SPACE VILLAGE FILING NO. 4
 A PORTION OF THE NW 1/4 OF SEC. 17, T14S,
 R65W, OF THE 6th P.M., EL PASO COUNTY, COLORADO
 DEVELOPMENT PLAN

**SPACE VILLAGE FILING NO. 4
 EL PASO COUNTY, CO**

**SHEET TITLE:
 COVER SHEET**

SHEET TITLE:
COVER SHEET

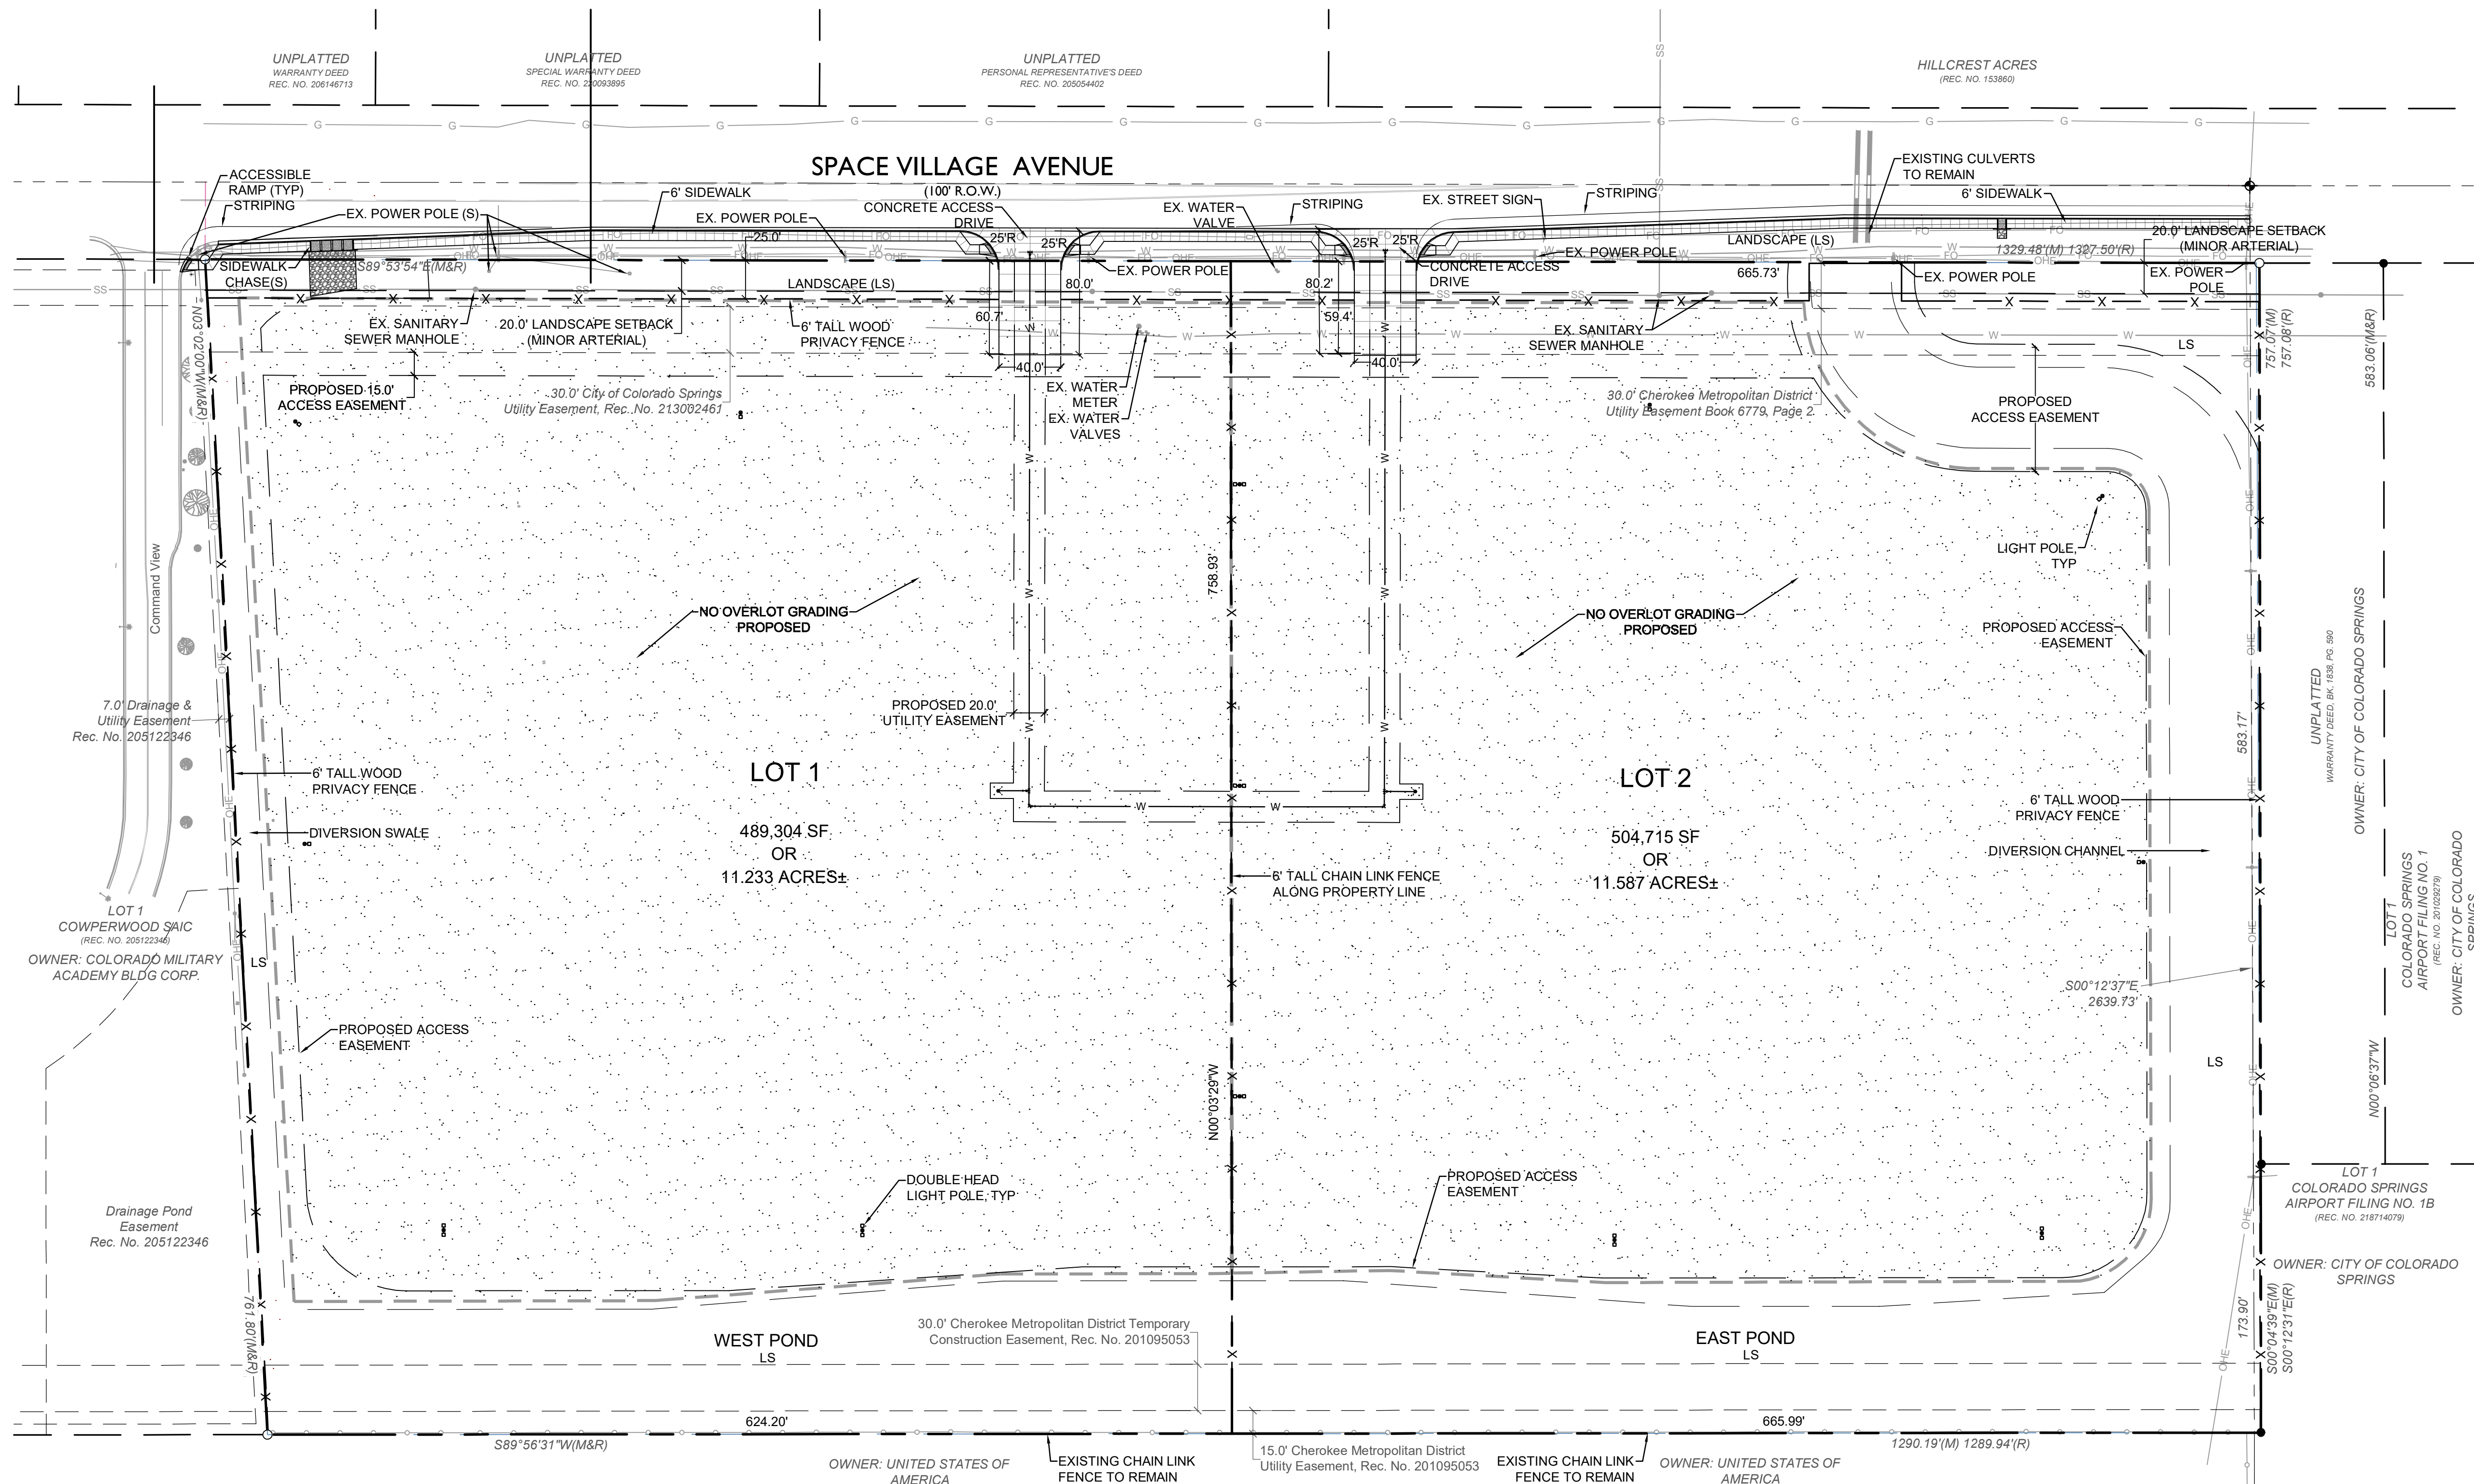
Unresolved Review 1 Comment:
 - Update to 719-520-6300

Unresolved Review 1 Comment:
 - Remove and replace with Ashlyn Mathy

Unresolved Review 1 Comment:
 - Add PCD Director's Signature Block.

Unresolved Review 1 Comment:
 - Provide Floodplain Zoning

Please add:
 Unresolved from v1

- Lot area coverage calculation
- Existing/proposed land use and zoning
- Total gross building square footage
- Open space, landscaping, and impermeable surface percentage

Unresolved Review 1 Comment:
 - Revise sheet numbers after removing "Preliminary Grading Sheet"

Unresolved Review 1 Comment:
 - Add "PCD File No. PPR-23-003"

Revised

Revised

PCD Director signature block added

Floodplain designation provided

Site Data Chart added

Sheet numbers revised

PCD file no. added

SHEET TITLE: SITE PLAN

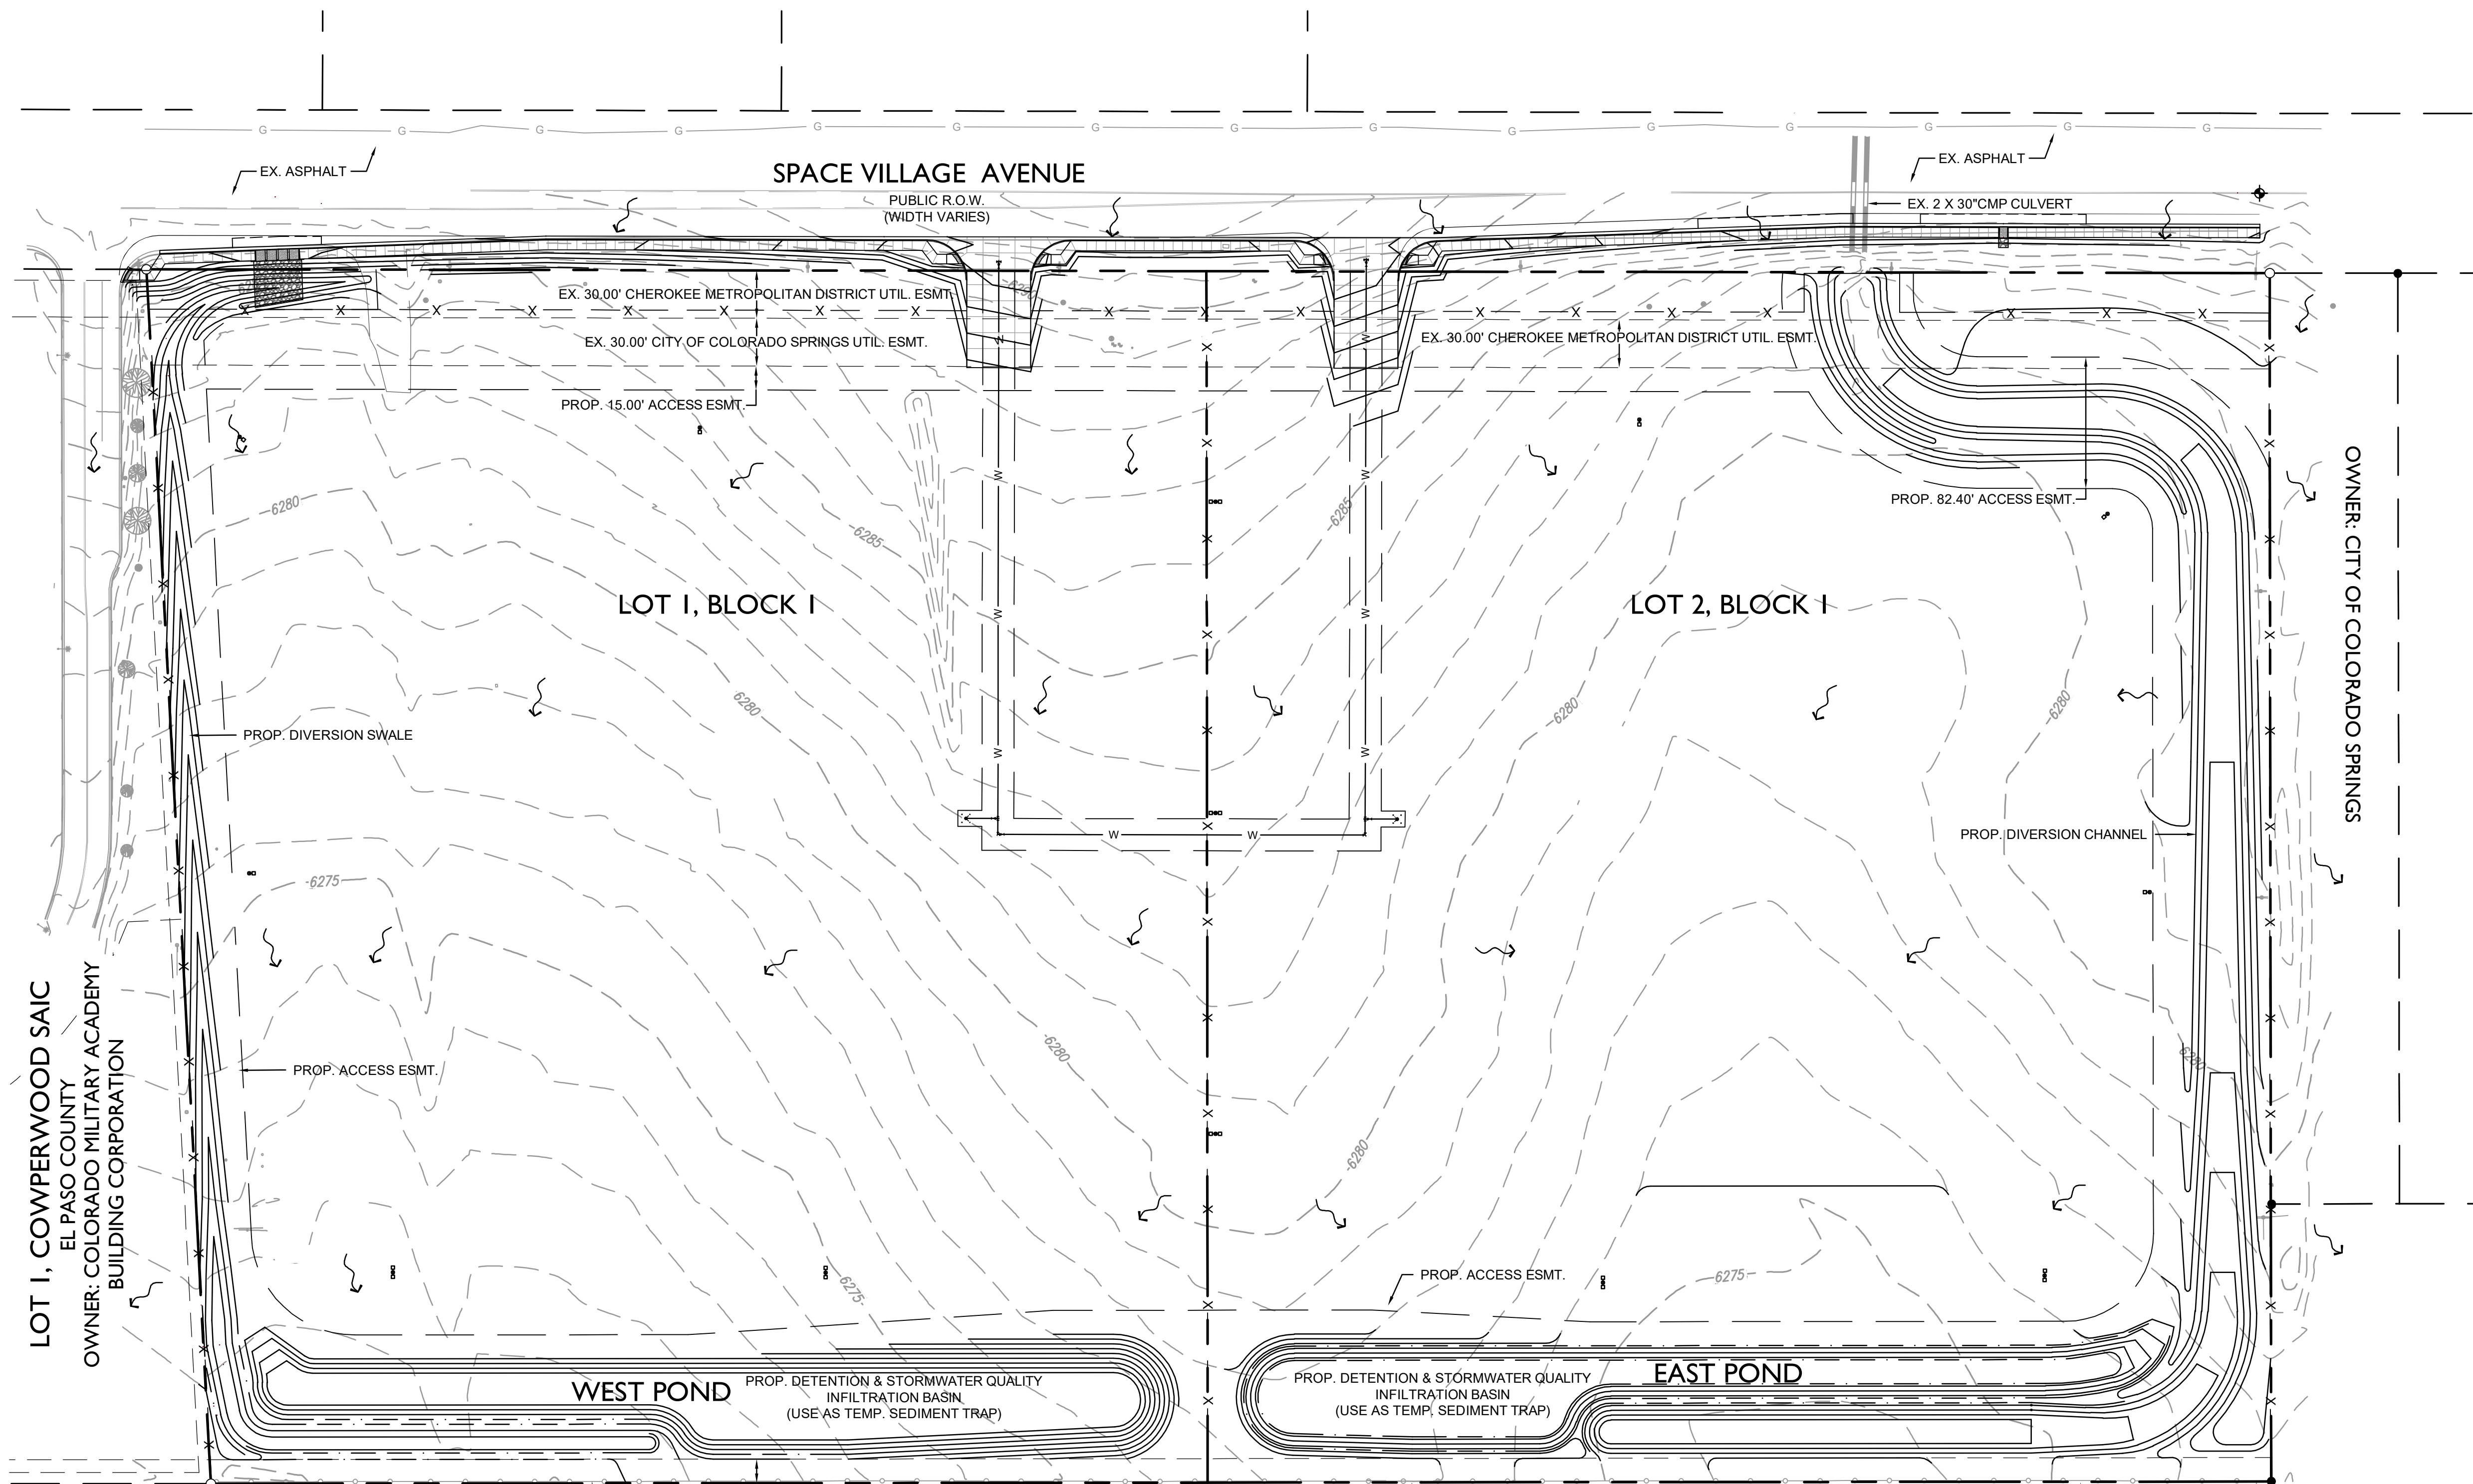
Please refer to GEC Plan in MS227 and update the site development plan accordingly.

See comments provided on the GEC Plan in MS227 regarding the recommended alignment from CDOT of the eastern driveway with the driveway on the opposite side of Space Village Avenue.

Please include: UNRESOLVED V1 (if none, then specify)

- Traffic circulation on site including all points of ingress/egress into the property
- The layout and location of all off-street parking, loading and other vehicular use areas, unless otherwise depicted in detail on a separate parking plan. If depicted on a separate parking plan then depiction of the parking areas are required.
- Location of all no-build areas, floodplain, drainageways and facilities
- Location of all garbage receptacles with a graphical depiction of the screening mechanism

SDP matches MS227 plans

Drive alignment revised.

Preliminary layout provided.
